Our ref: XA/2024/100105/01-L01

A46 Newark Bypass – Development Consent Order Application

A46 from Farndon Roundabout to Winthorpe Roundabout, near Newark-On-Trent

Registration as Interested Party and Submission of Relevant Representations

**Figure 3-2 Interface with Cree's Lane embankment**

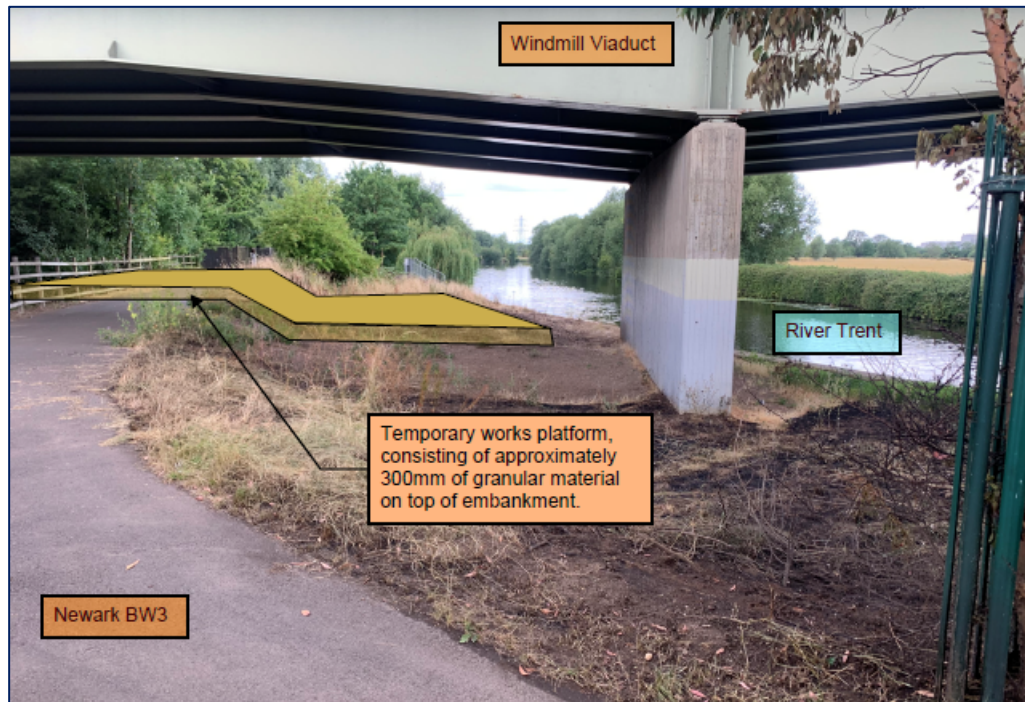
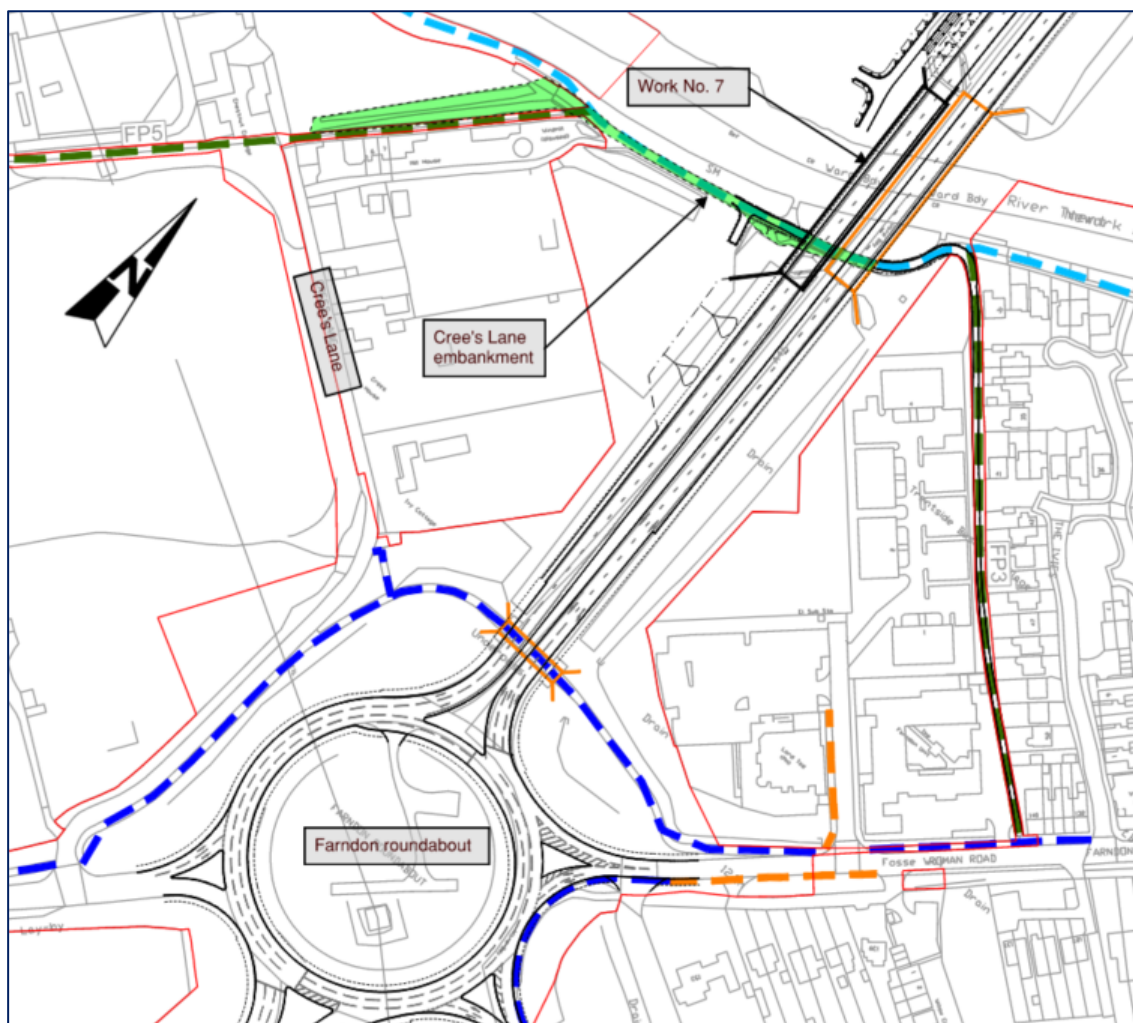
understand the flood implications. Without this information we cannot be confident in our assessment of the flood risks, both to the development and to third parties, resulting from the realignment, and what could be done to mitigate any potential flood risks.
Solution	Detailed drawings should be provided and with-mitigation scheme modelling re-run with the realignment to understand the flood risk impacts.
Topic	Interaction with Environment Agency flood defences
Document references	APP-177 – 6.3 Environmental Statement - Appendix 13.2 Flood Risk Assessment (ref. TR010065/APP/6.3, Revision 1, April 2024)
Issue reference	EAFR-008
Issue	There is limited information available on the Scheme’s interaction with the existing Environment Agency flood defences. The FRA mentions that the Scheme will ‘tie-in’ with existing Environment Agency flood defences (see paragraphs 3.4.2 and 7.7.2), but there is no explanation for how this will occur, or how it will be ensured that there will be no detriment to the defences.

Impact	<ul style="list-style-type: none"> • FRA paragraph 7.7.2 states that the “scheme design directly interfaces with these flood defences and suitable measures have been put in place in order that the existing defences are not structurally compromised or altered in terms of crest height”. However, without further details of how this interface will be managed, we cannot confirm whether proposals are acceptable. • There is no evidence to demonstrate that the proposal will not restrict essential maintenance and emergency access to the defences (the permanent retention of a continuous unobstructed area is an essential requirement for future maintenance and/or improvement works), or whether the proposed development is likely to adversely affect the construction and stability of the flood defences, which will compromise their function.
Solution	<ul style="list-style-type: none"> • Further information should be provided on the current Standard of Protection (SoP) of the existing defences, their composition, current condition, and inspection regime. • Detailed plans for areas around the defences, showing tie-in with the Scheme, should be provided. The lifetime of the defences should ideally be commensurate with the lifetime of the Scheme, so if this is not the case then the Applicant should consider opportunities to ensure they are brought up to the Scheme’s lifetime.
